CITY OF ALBUQUERQUE

November 16, 2016

Re: Campbell Brewery -4814 Hardware NE
90-Day Temporary Certificate of Occupancy- Traffic Certification Only
Architect's Stamp dated 08-07-15 (F17D097)
Certification dated 11-16-16

SITE PLAN

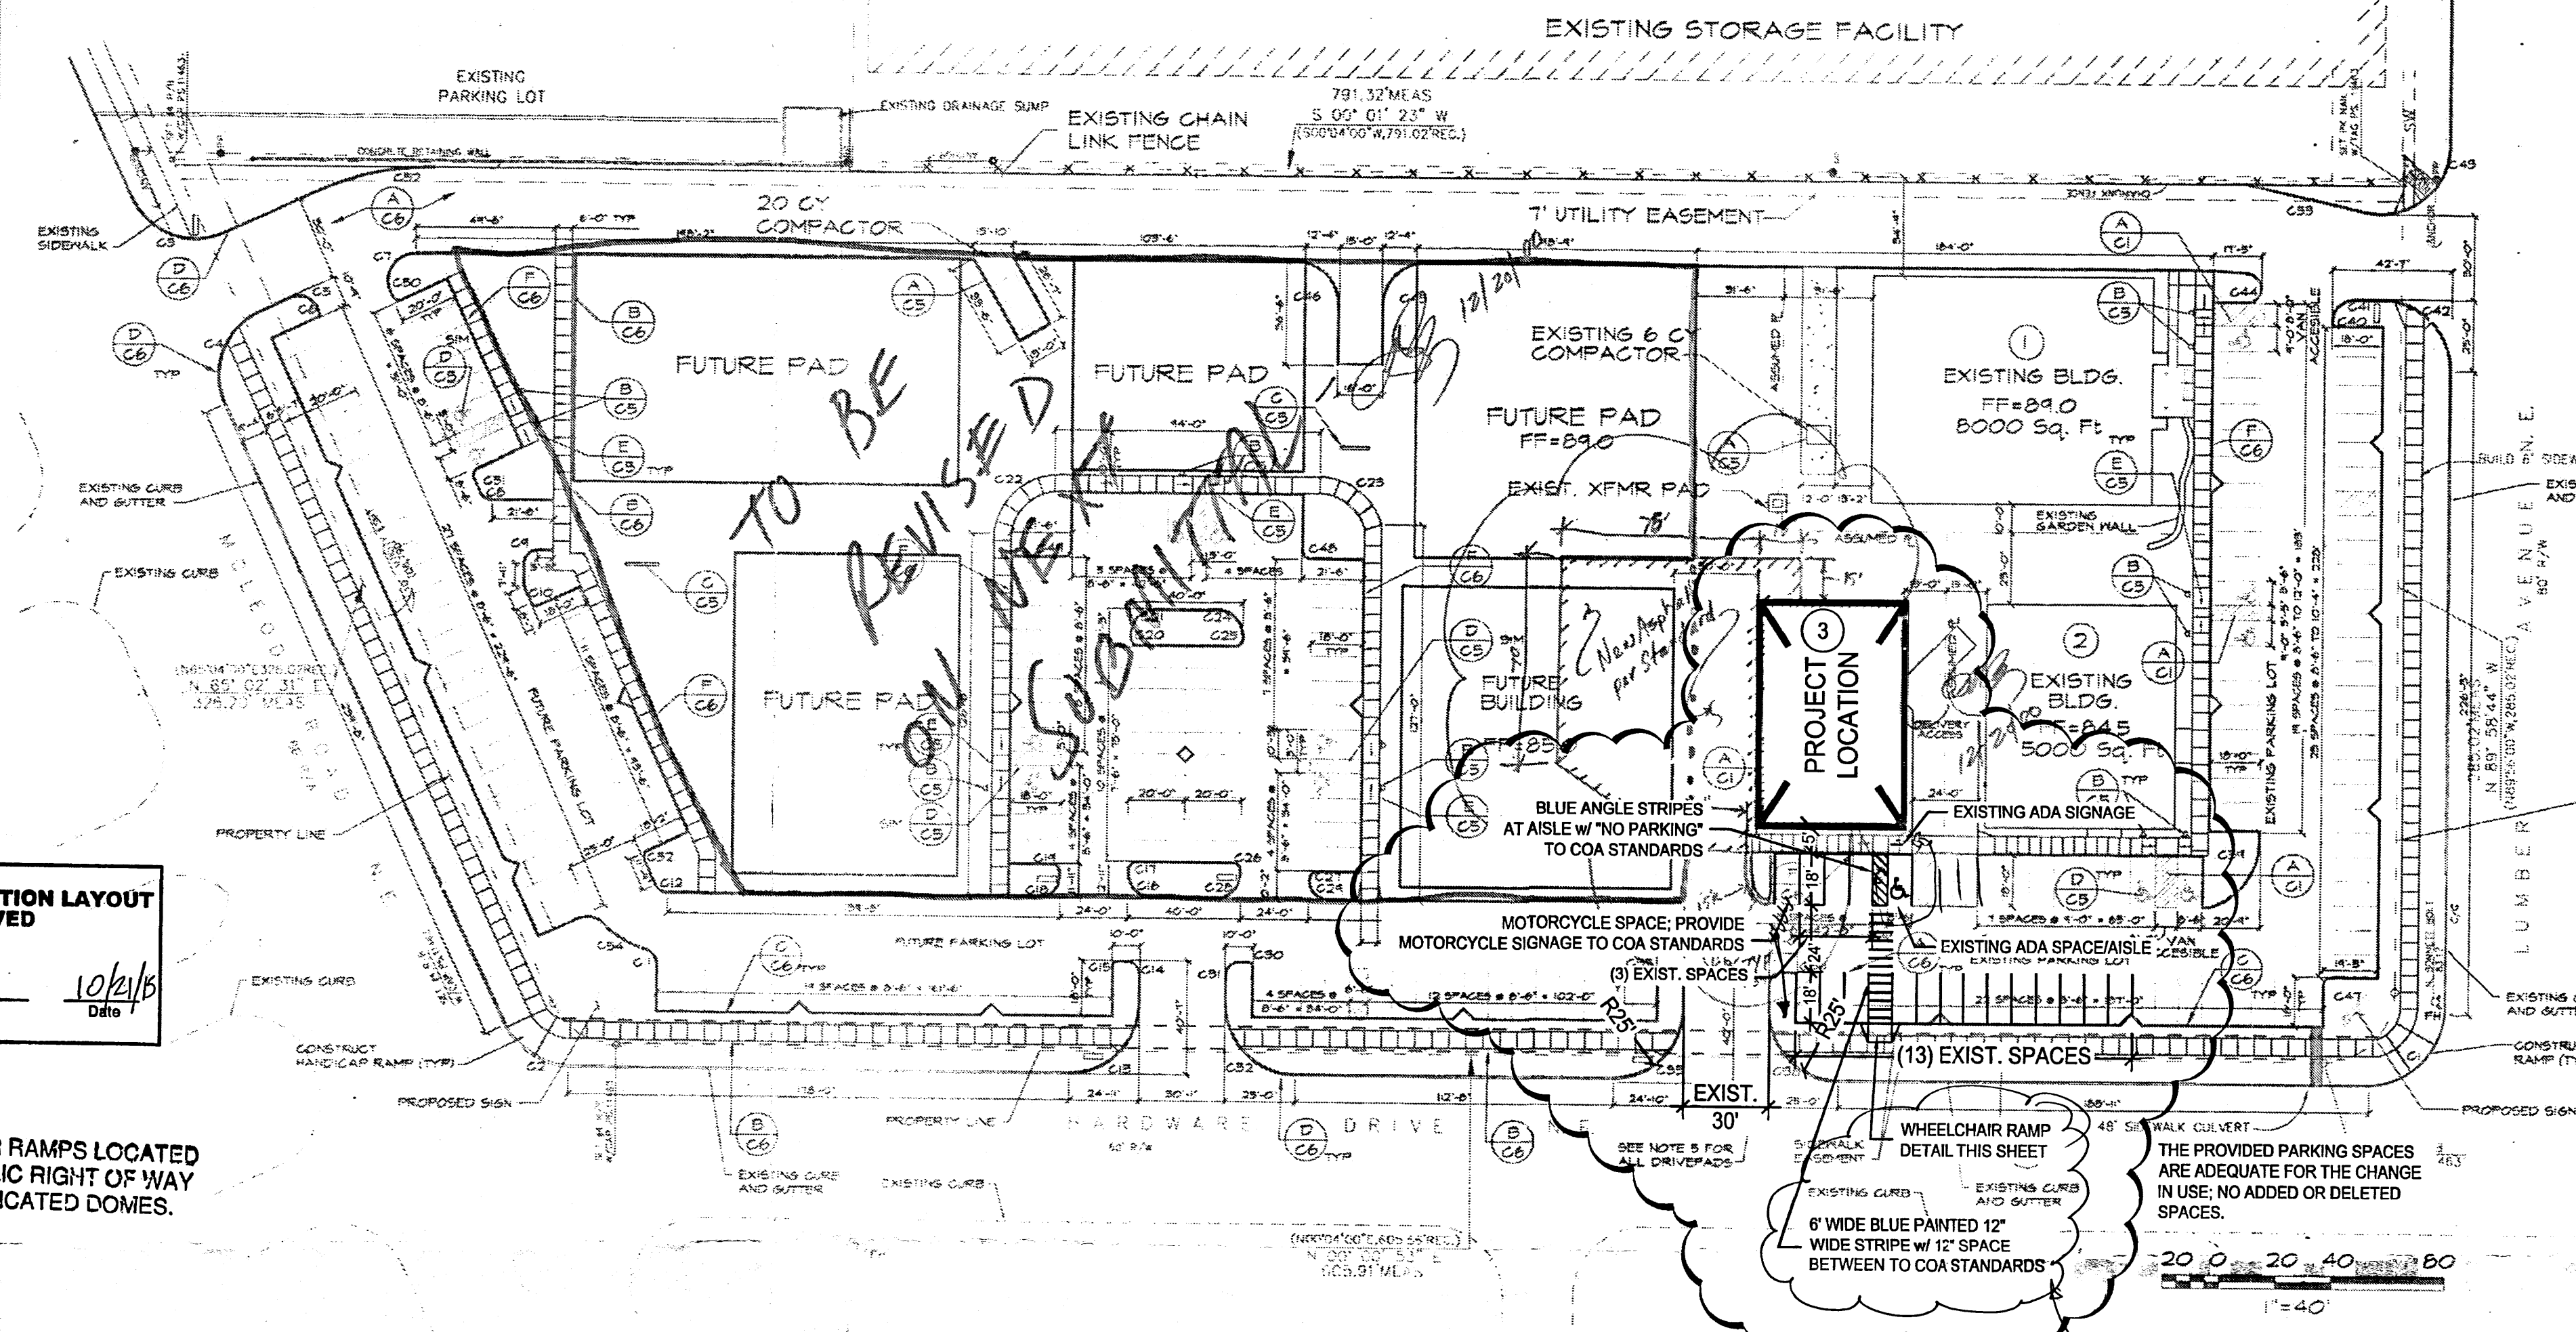
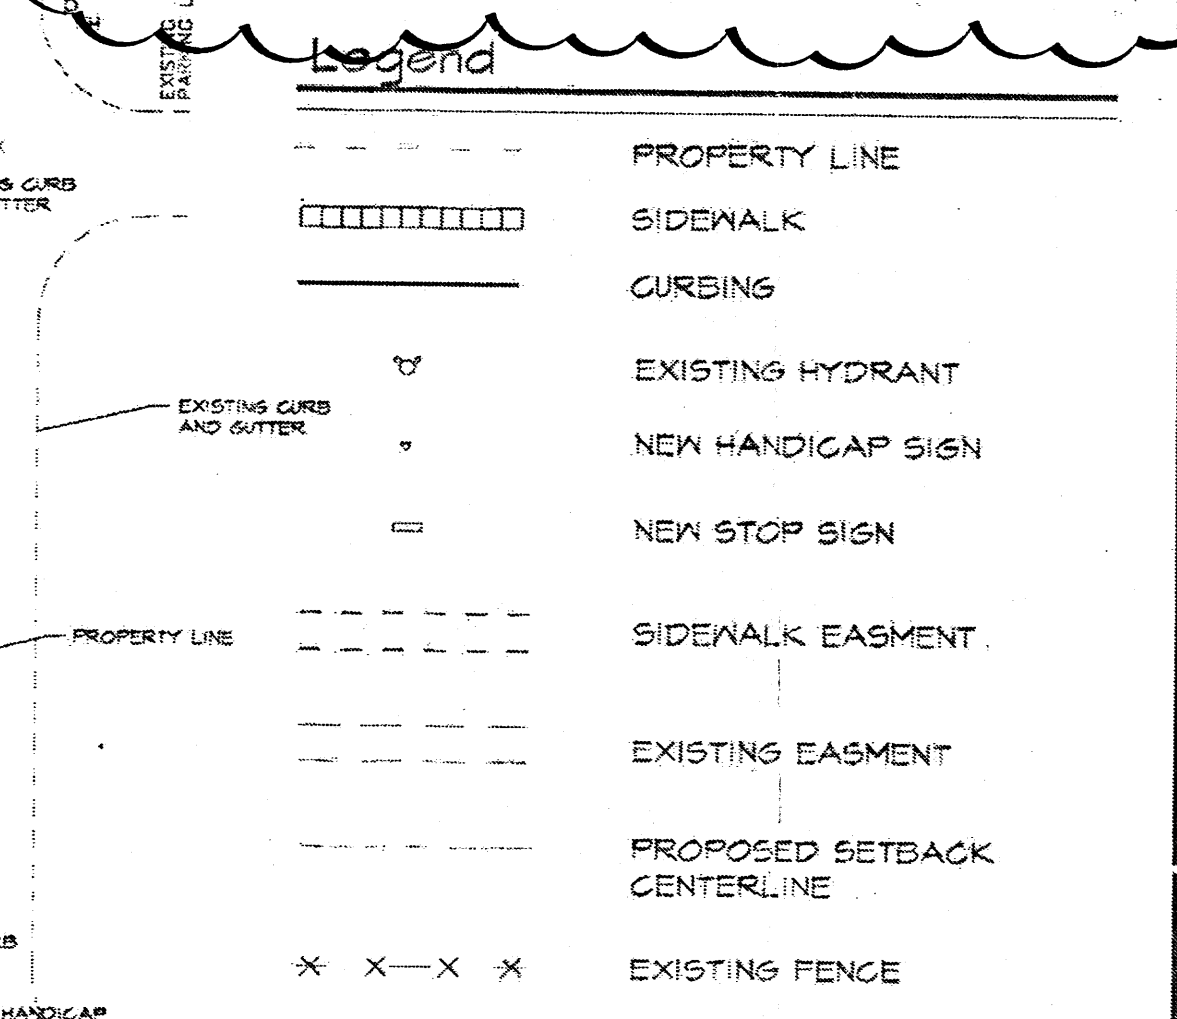
1. The 6' pedestrian access to the site must be constructed and striped per the approved TCL.
2. The approved and stamped TCL, with any changes drawn in red.
3. Transportation Certification letter on either the plan or applicants letterhead.
4. A Drainage Transportation Information Sheet (DTIS)
5. Send an electronic copy of your submittal to PLNDRS@cabq.gov.
6. A site inspection will be completed.
